From: [REDACTED]
Sent: 13 November 2018 12:49
To: 'chris barrow'
Subject: RE: Middleton road block plan

38, Middleton Road, Felpham, West Sussex, PO22 6BT

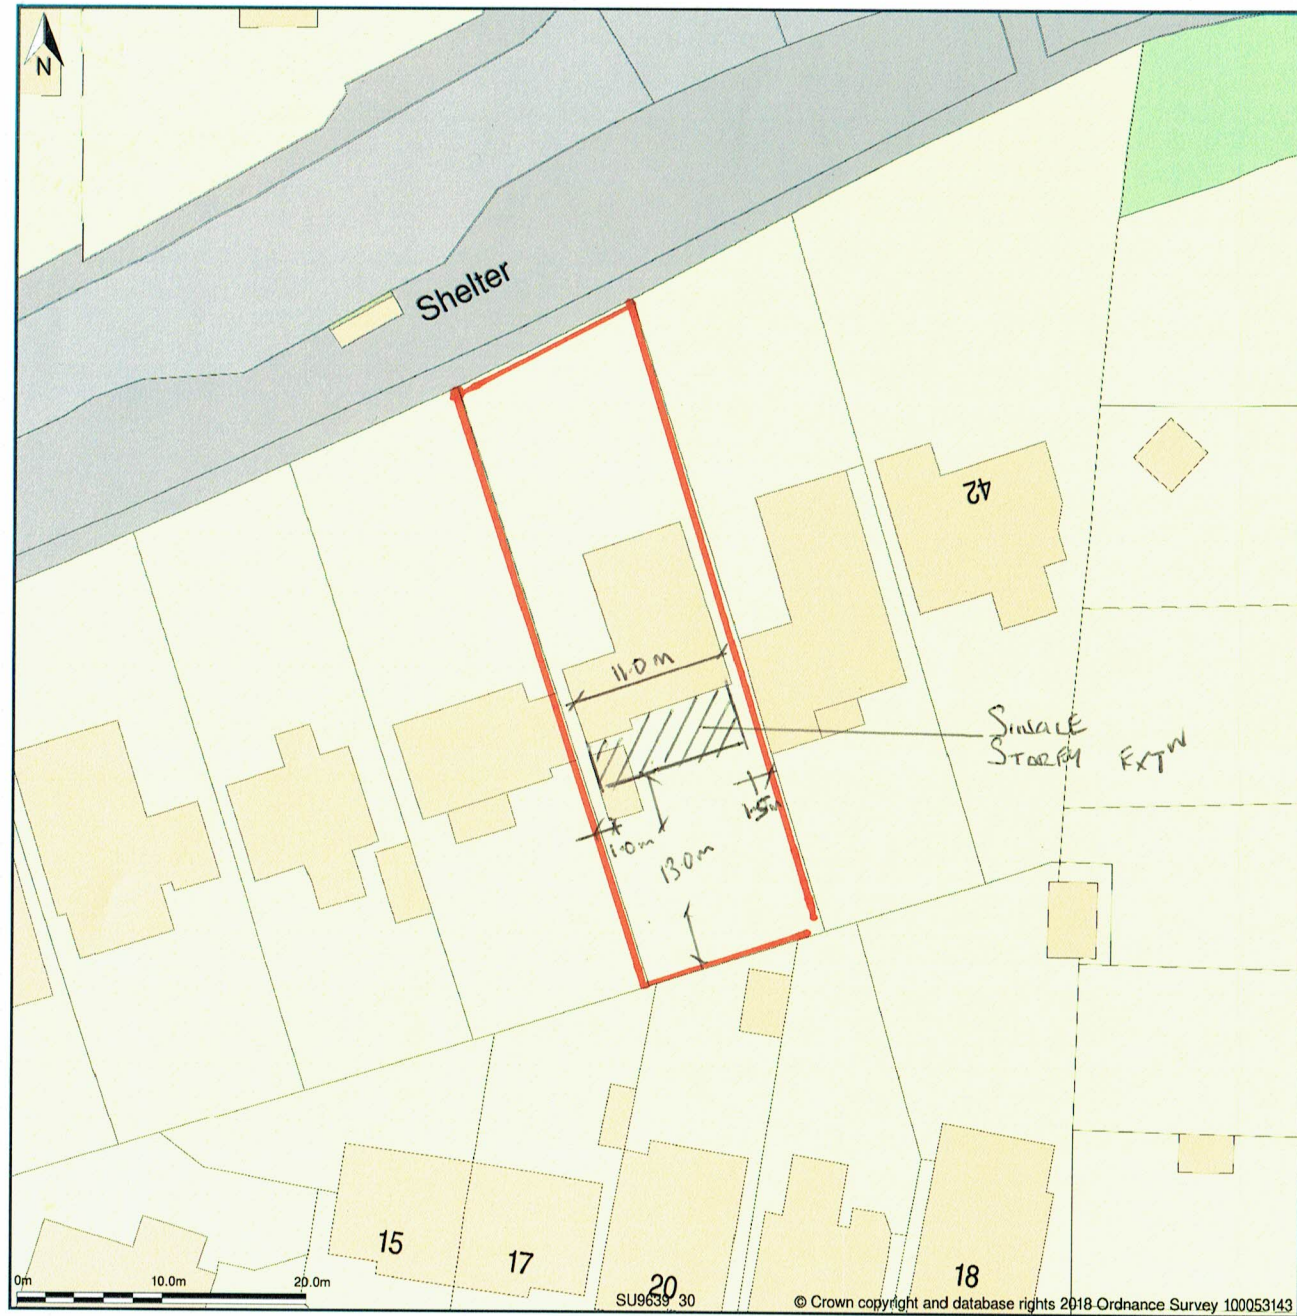
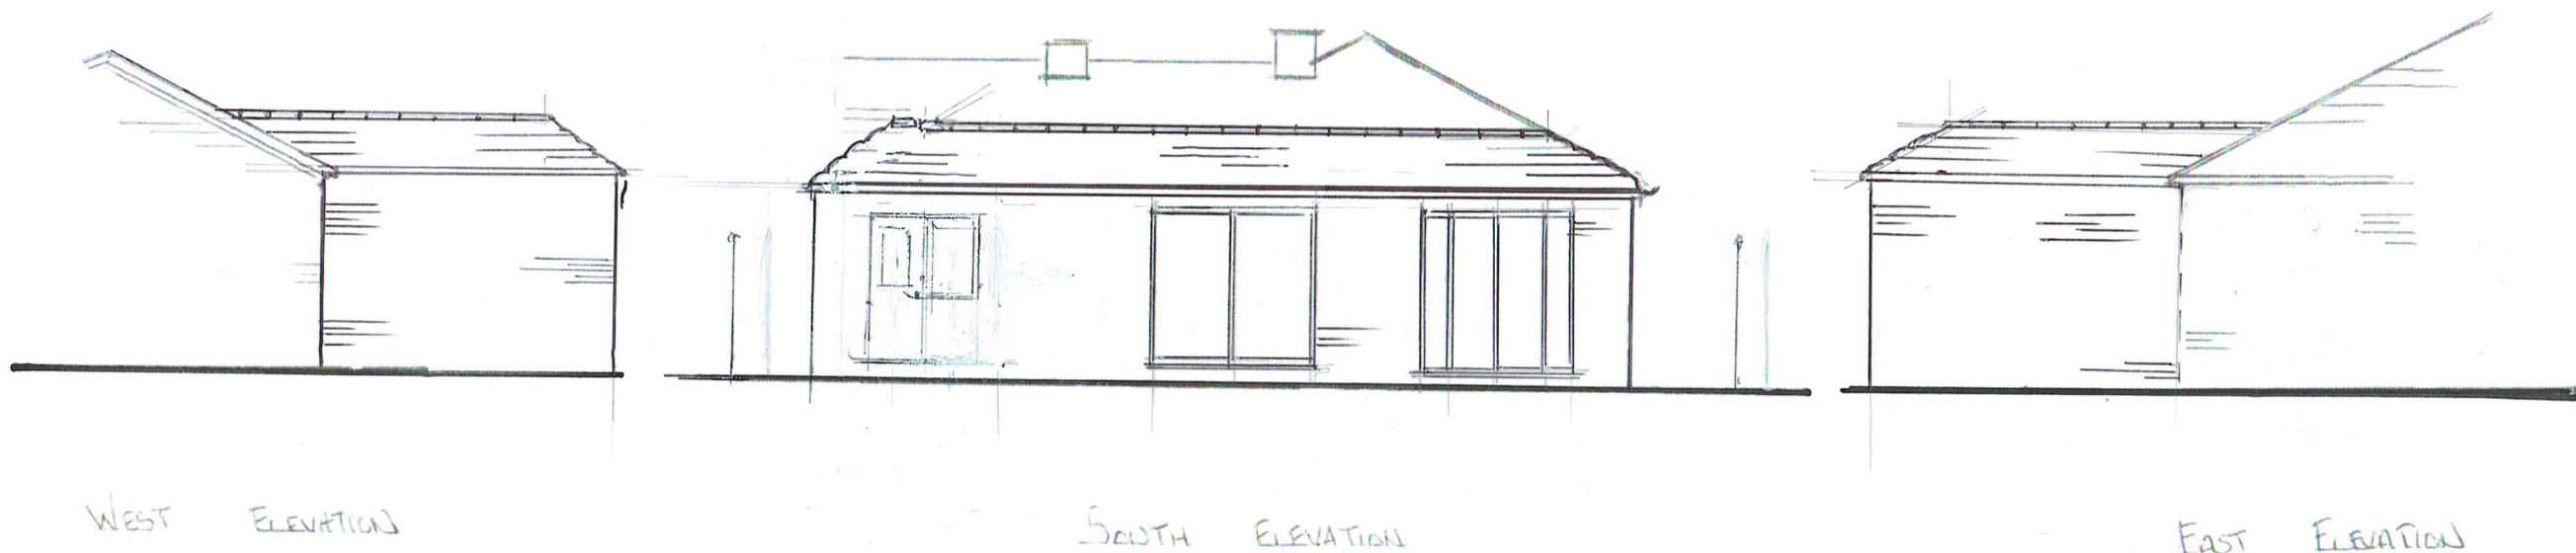
Thank you for your email. However, the application is still invalid as the width/shape of the extension does not match between the block plan and the proposed floor plans. In addition to this, the dimension of 1m (on the right hand side) is incorrect.

GROUND FLOOR PLAN
[AS PROP']

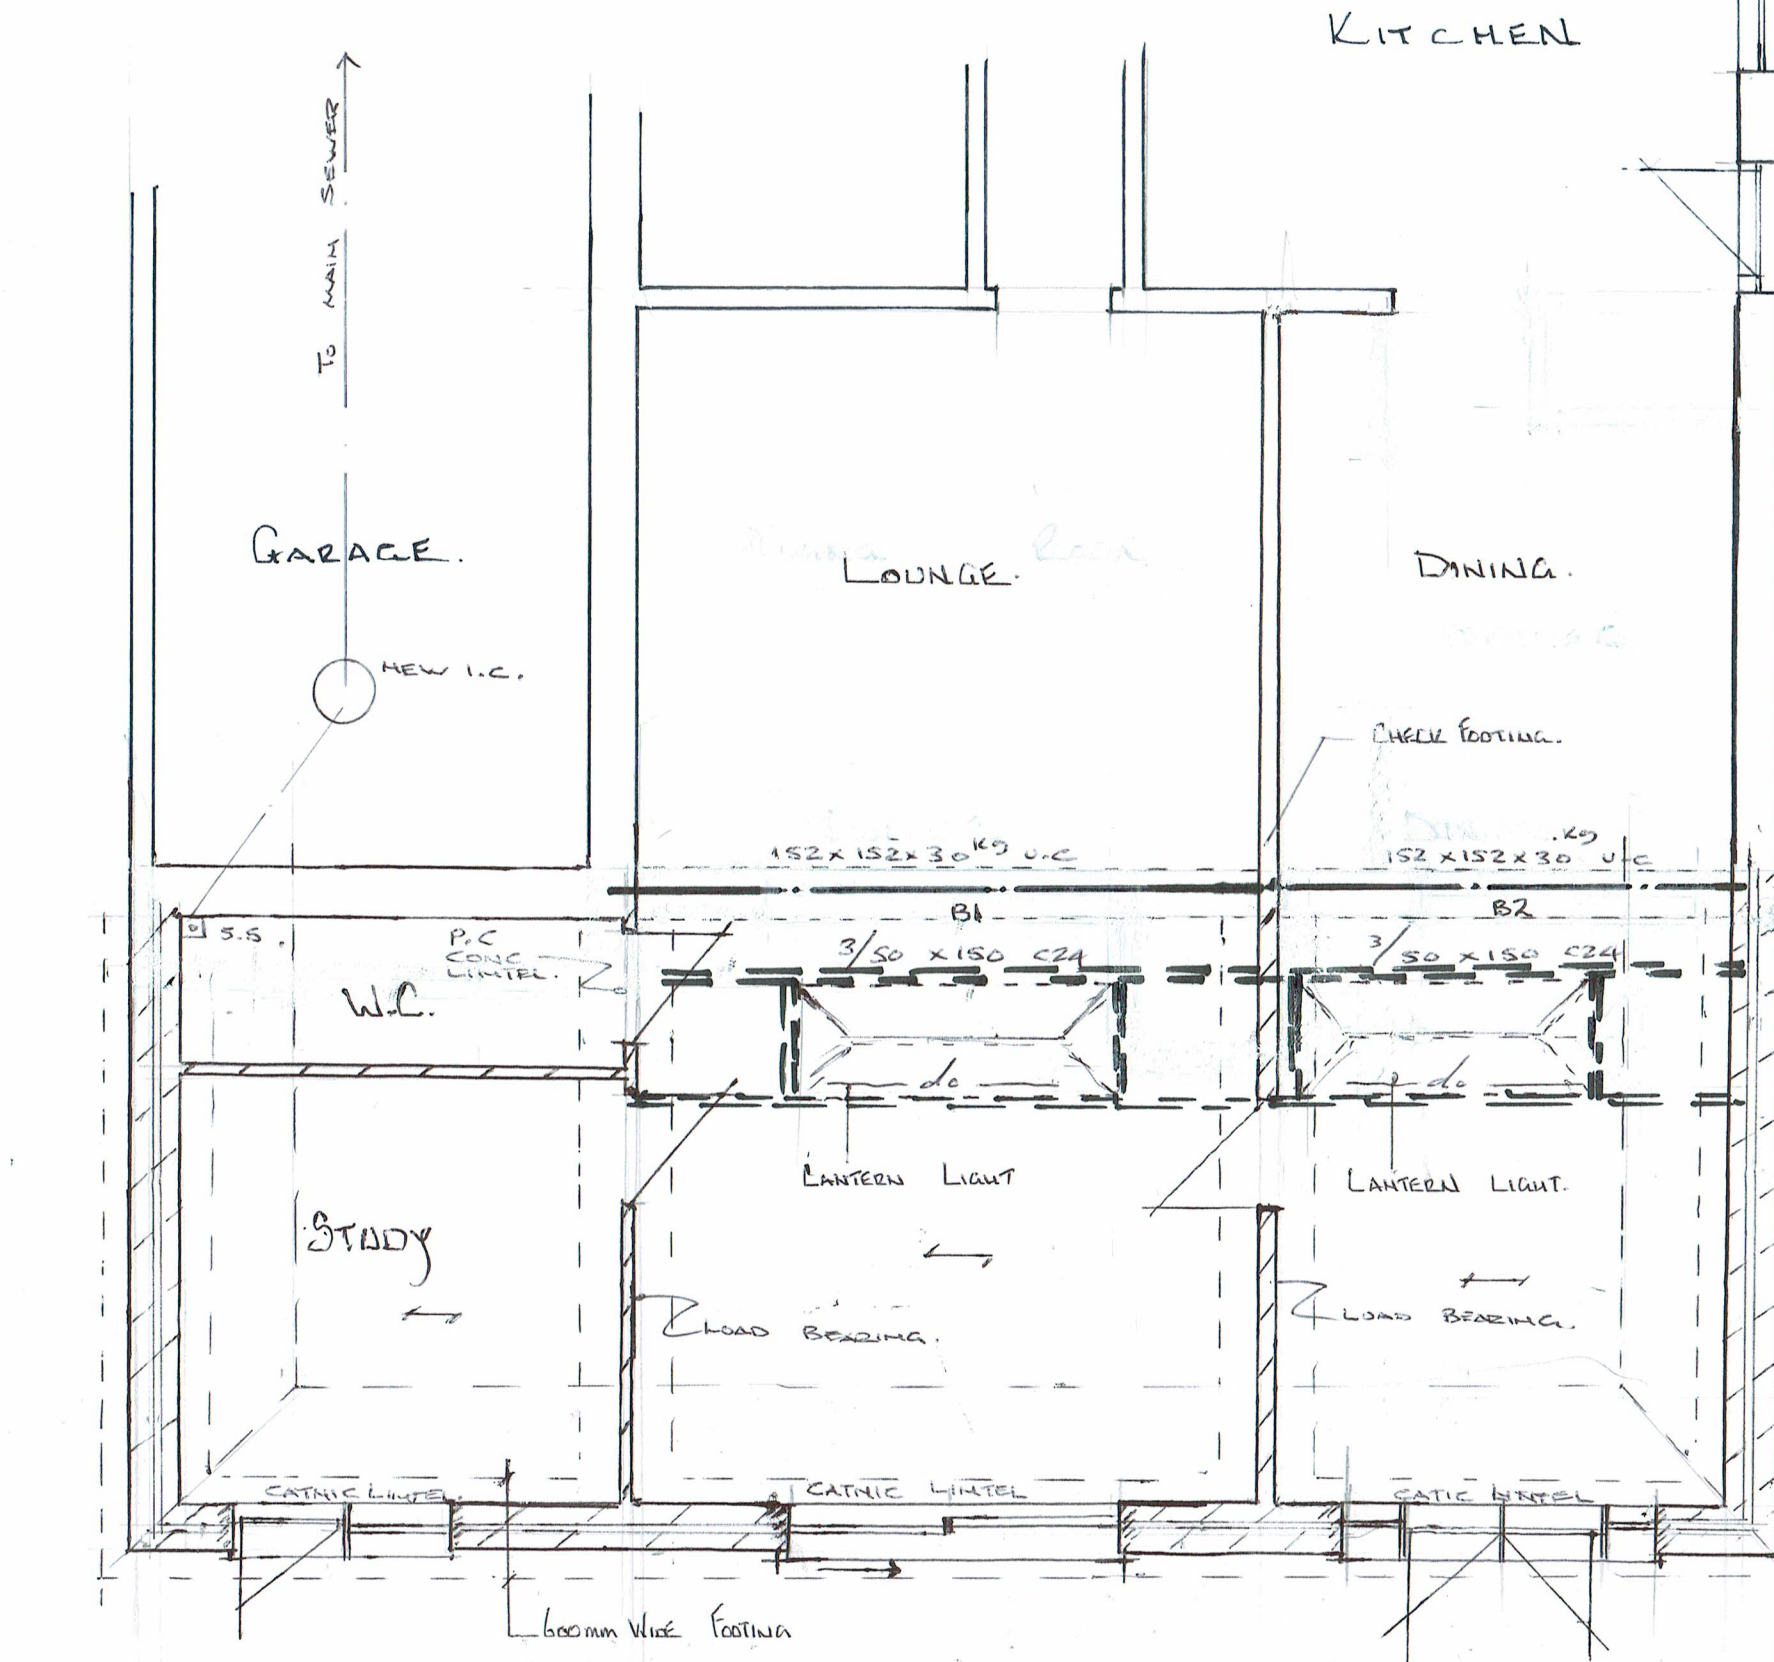
In respect of the width not matching between the proposed floor plan and the rear elevation, we do not print the plans and the plans have been scanned at the same paper size as the original by the council, therefore it appears that the inconsistency is with the original version of the plan.
